Project# 11009161616 Application # 15DRB-70080

**PROJECT NAME:** Anderson Addition; Paris Addition

**RE: Anderson & Paris Additions**

**RE: Block 4, Paris Addition & Block 5, Anderson Addition**

TOPOGRAPHIC AND BOUNDARY SURVEY OF

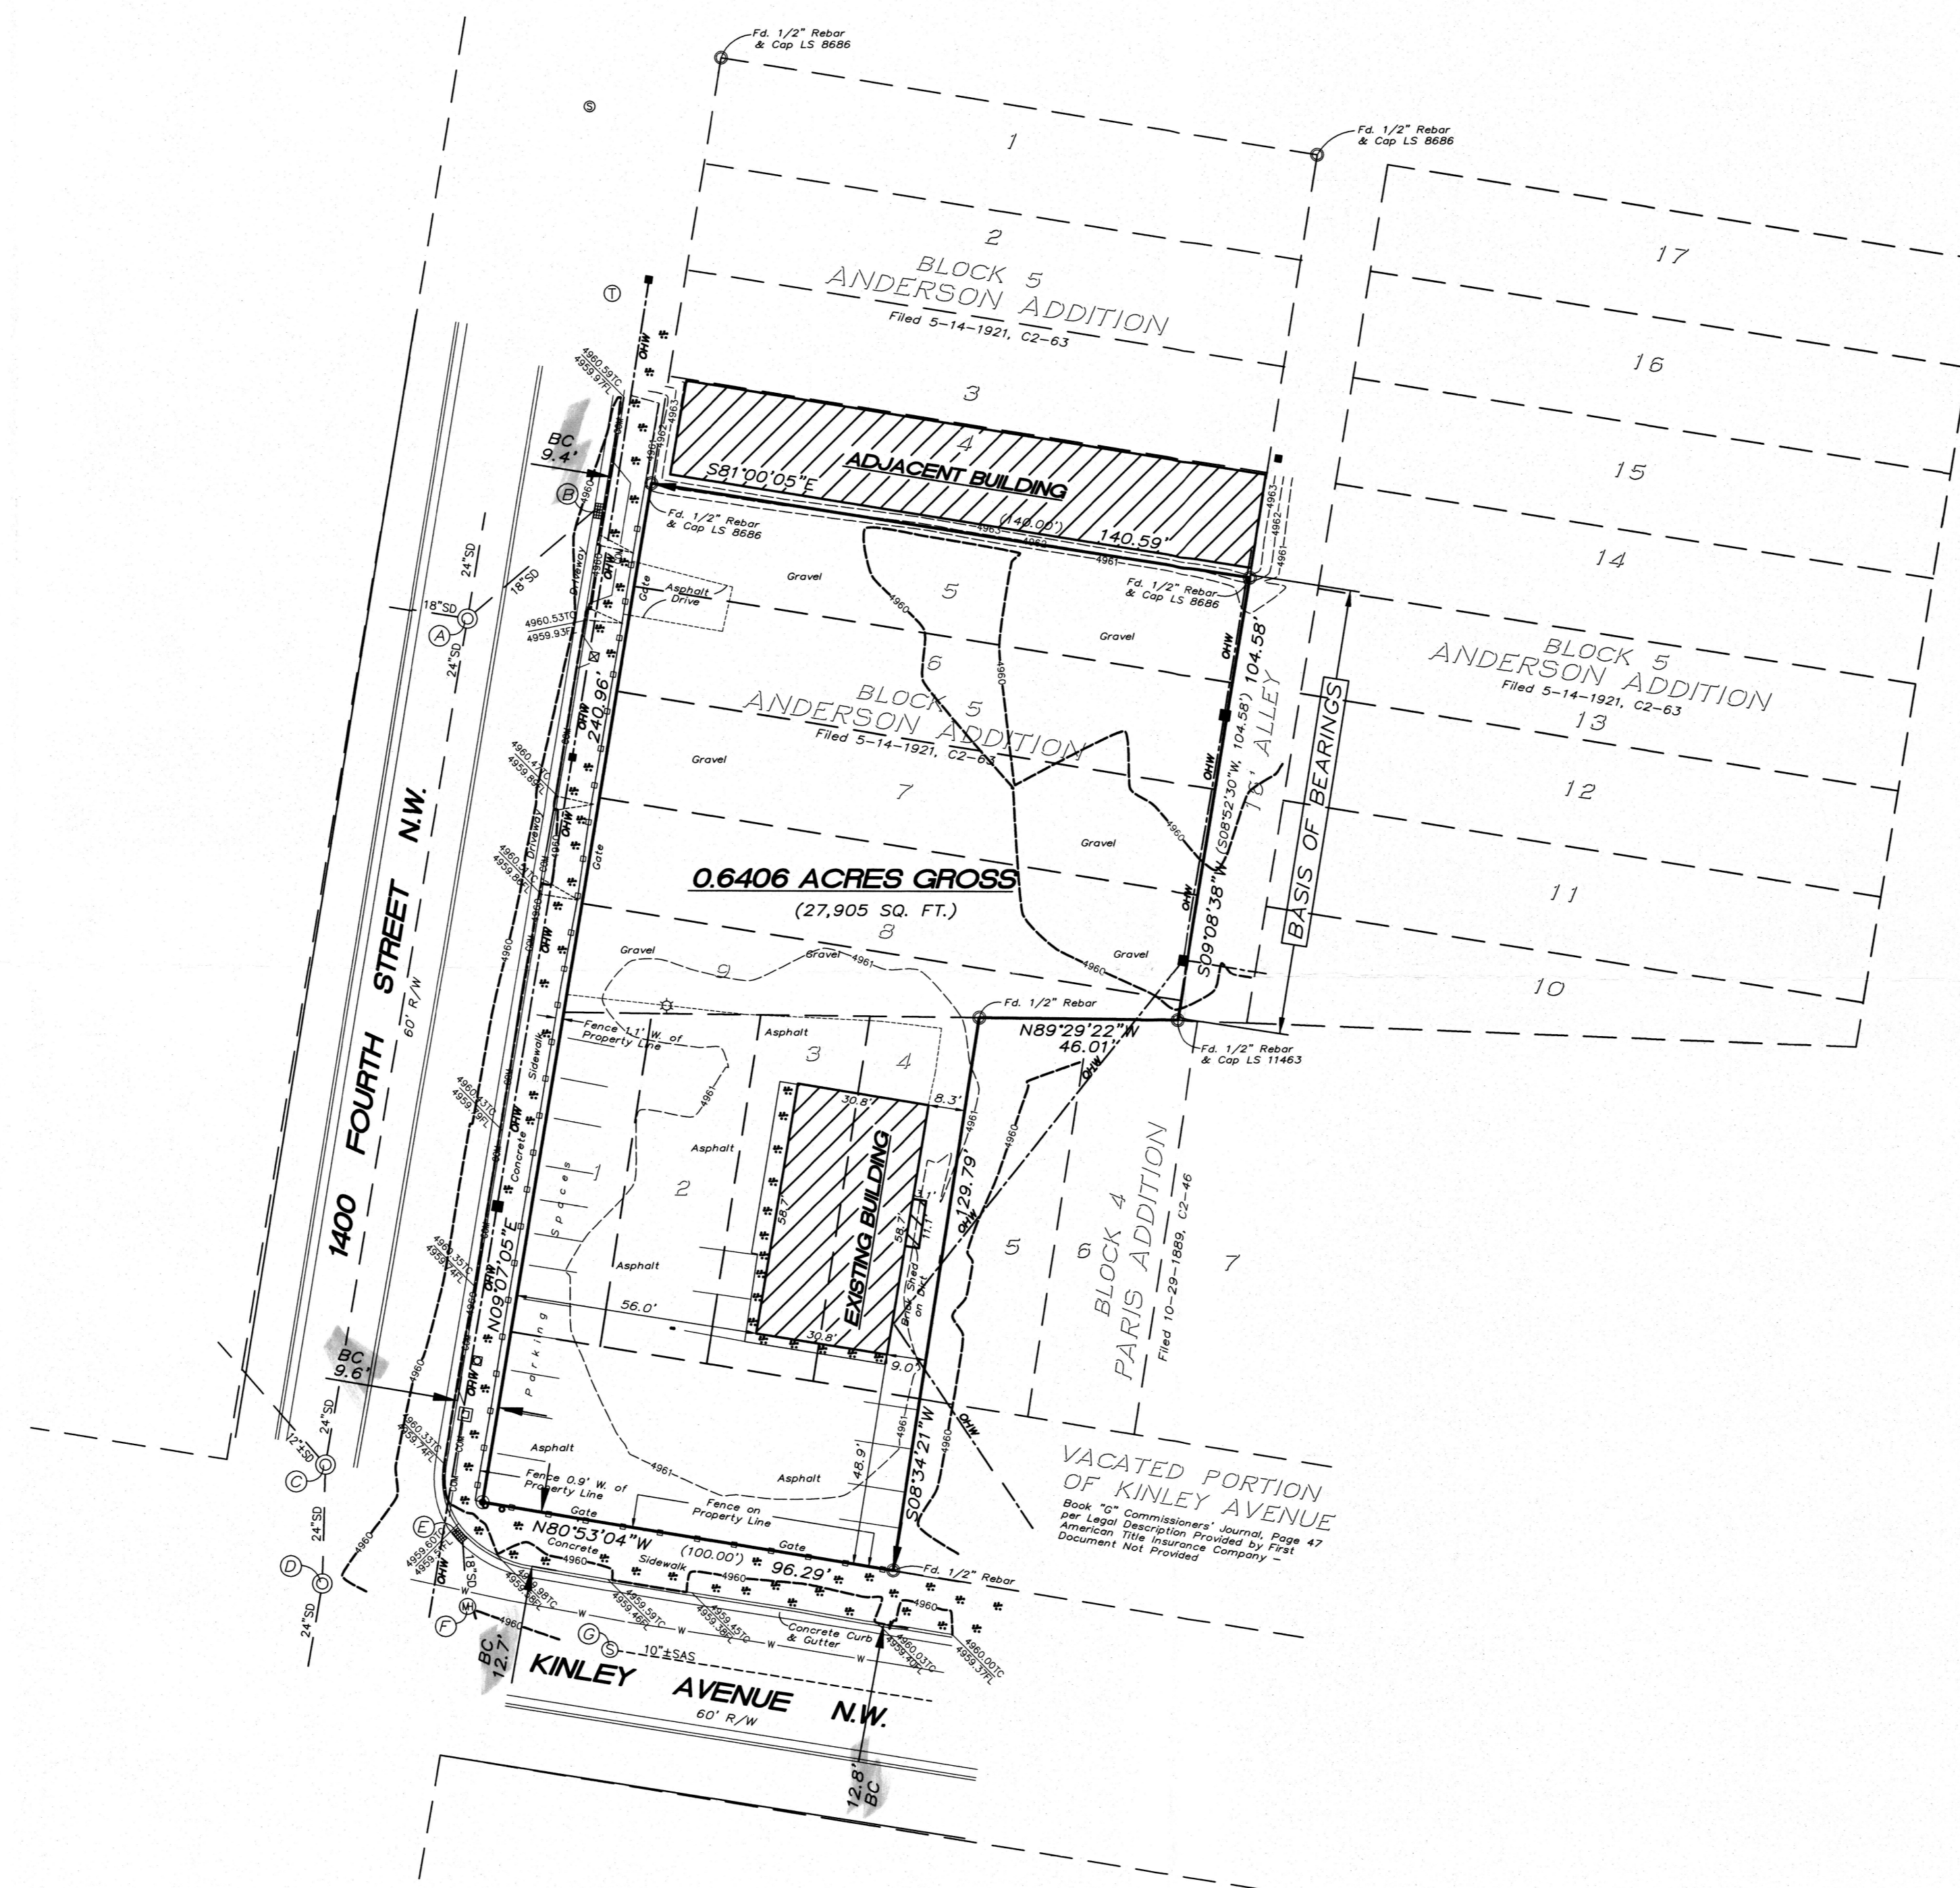
Per Sketch Plat comments, parking layout needs to be shown; this layout needs to conform to DPM requirements.

For platting, parking calculations (required and existing) and layout need to be shown for existing building (proposed corner lot) to demonstrate compliance with on-site parking requirements of the Zoning Code.
